Our ref: DOC20/788728
Senders ref: SSD-9320662

Subject: EES comments on Request for SEARs – Cobra Waste Solutions – Resource Recovery Facility – 30 Loftus Road Yennora– SSD-9320662

Thank you for your email of 18 September 2020 requesting advice in relation to this State Significant Development. The Environment, Energy and Science Group (EES) has reviewed the Scoping Report and provides the following comments and recommendations in Attachment A.

Figure 1 – Site location (taken from BDAR Waiver Request report - DOC20/780213-2)

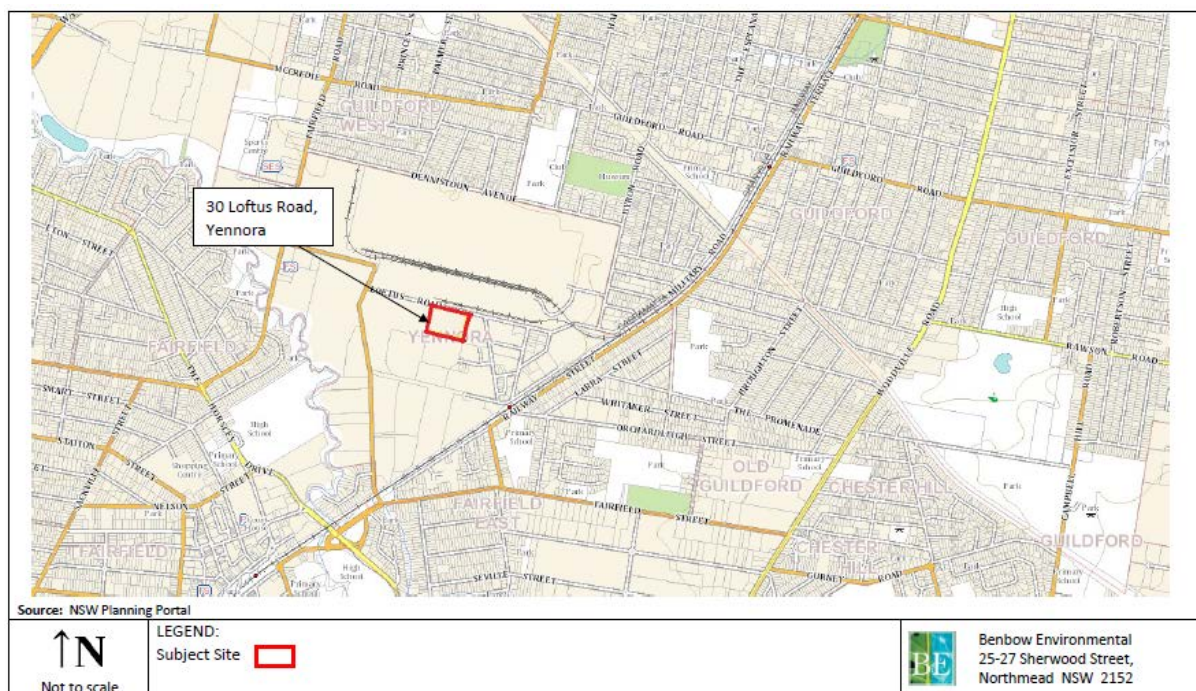
The BDAR waiver report notes there are recently planted mature-size gum trees on the northern and western boundary of the site and this vegetation is to be retained (page 10). EES notes the Site Plan and Truck Movement plan attached to the Scoping Report show trees along the western boundary but none along the northern boundary. The EIS should clarify this.
